WEST SUSSEX COUNTY COUNCIL CONSULTATION

TO:	Arun District Council FAO: Jessica Riches
FROM:	Stephen Gee WSCC – Highways Authority
DATE:	7 October 2024
LOCATION:	Land at Ford Airfield Ford
SUBJECT:	F/14/24/RES Approval of reserved matters (layout, scale, appearance and landscaping) following outline consent F/4/20/OUT for the infrastructure RM including the provision of a primary spine road and associated secondary road junctions, pavement, footpaths, cycle infrastructure and bus stops; site wide drainage infrastructure including foul pumping stations, foul sewer infrastructure, SUDS basins, SUDS swales, surface water infrastructure; acoustic fencing; public open space including landscape details, play areas, footpaths & associated works. This application affects a Public Right of Way, may affect the setting of a Listed Building and falls within CIL Zone 1 (Ford strategic site - zero rated).
DATE OF SITE VISIT:	n/a
RECOMMENDATION:	Advice / More Information

IRM - VEHICLE TRACKING AND
VISIBILITY PLAN (SHEET 3 OF 7)

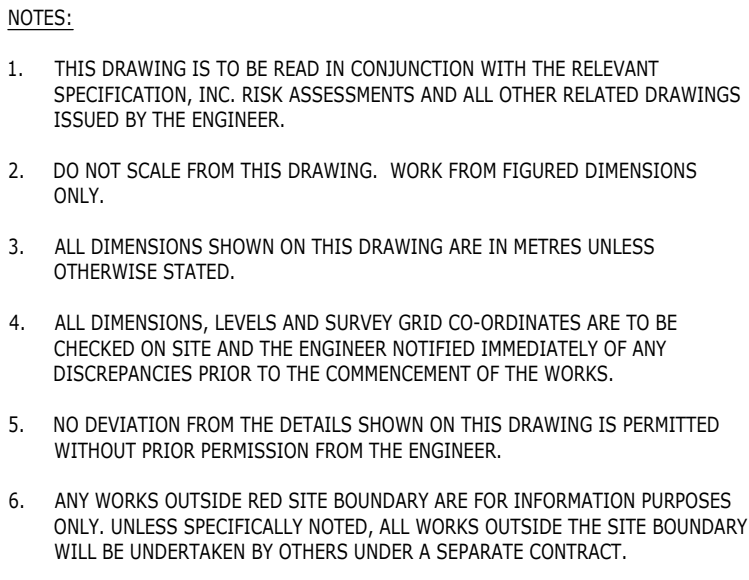
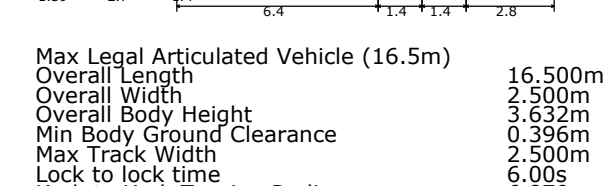
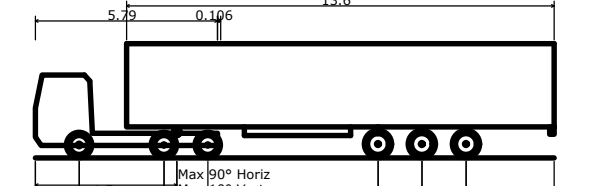
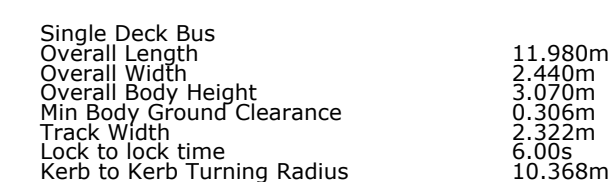
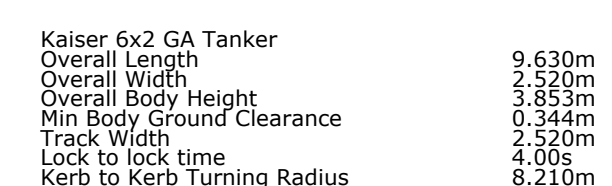
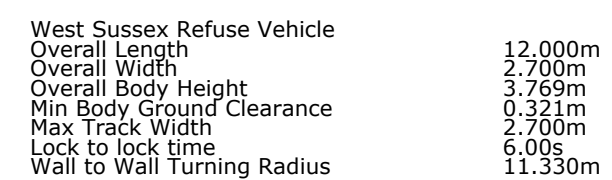
Whilst the plans provided with the transport information are titled 'vehicle tracking and visibility plans' no visibility splays can be seen.
